Development Facilitation Team (DFT) – Review Comments

Project No: PR-2025-011406 Date: 3/26/2025 Agenda Item: #5 Zone Atlas Page: J-13

Request: for DHO Waiver Determination to allow for a 16' Alley Right of Way.

Location: 701 14th St NW

# SITE PLAN LOT 23-A, BLOCK 41 PEREA ADDITION

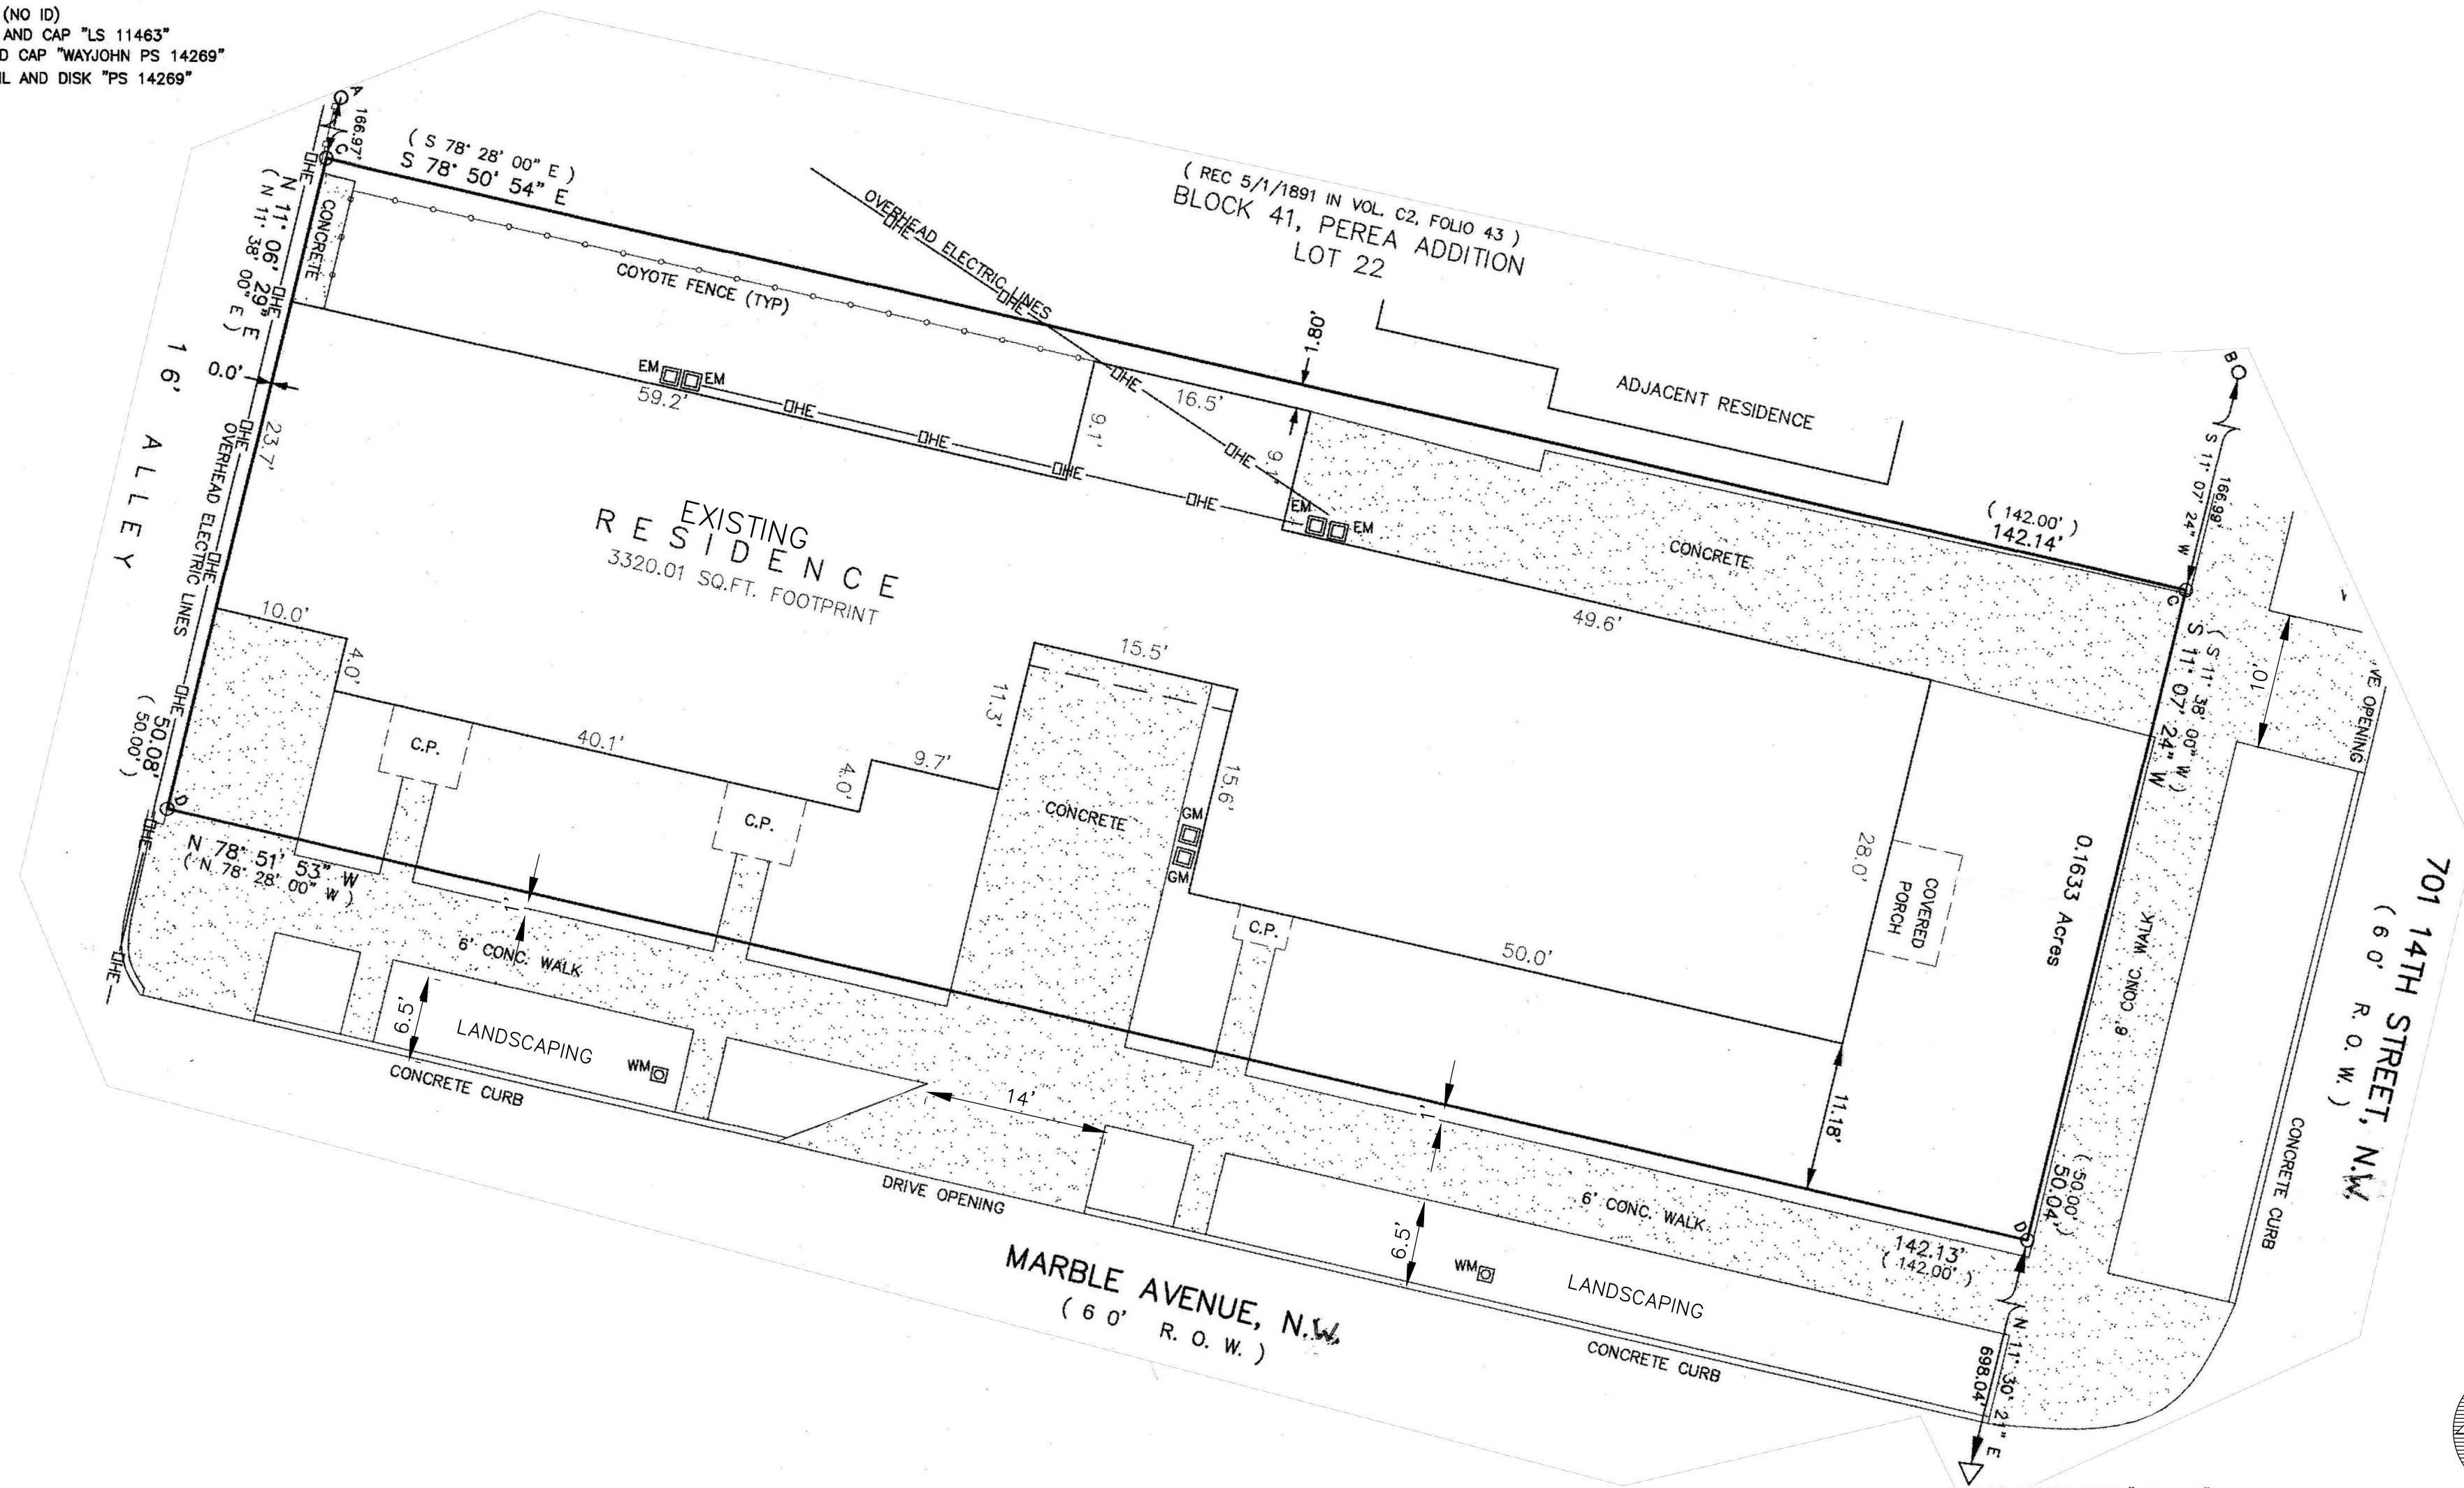
1. No objection
 - a. The request to waive the 20-ft requirement for width of the alley right-of-way, which includes an 8- inch sanitary sewer line is not unreasonable since the width of the alley between existing parcels with buildings/structures on either side of it is only about 17- 17.5 feet.

1. Transportation has no objection to the determination as there are numerous physical obstructions to prevent widening of the alley.

- **Planning staff recommends approval of this Waiver. The applicant has adequately justified that enforcing the minimum alleyway width of 20' outlined by the DPM would be impossible to achieve due to pre-existing obstructions on the site. The site in question is in an already fully developed area that has been built around the existing 16' walkway. Enforcing the 20' minimum rule would cause significant materially adverse impacts on the surrounding area.**
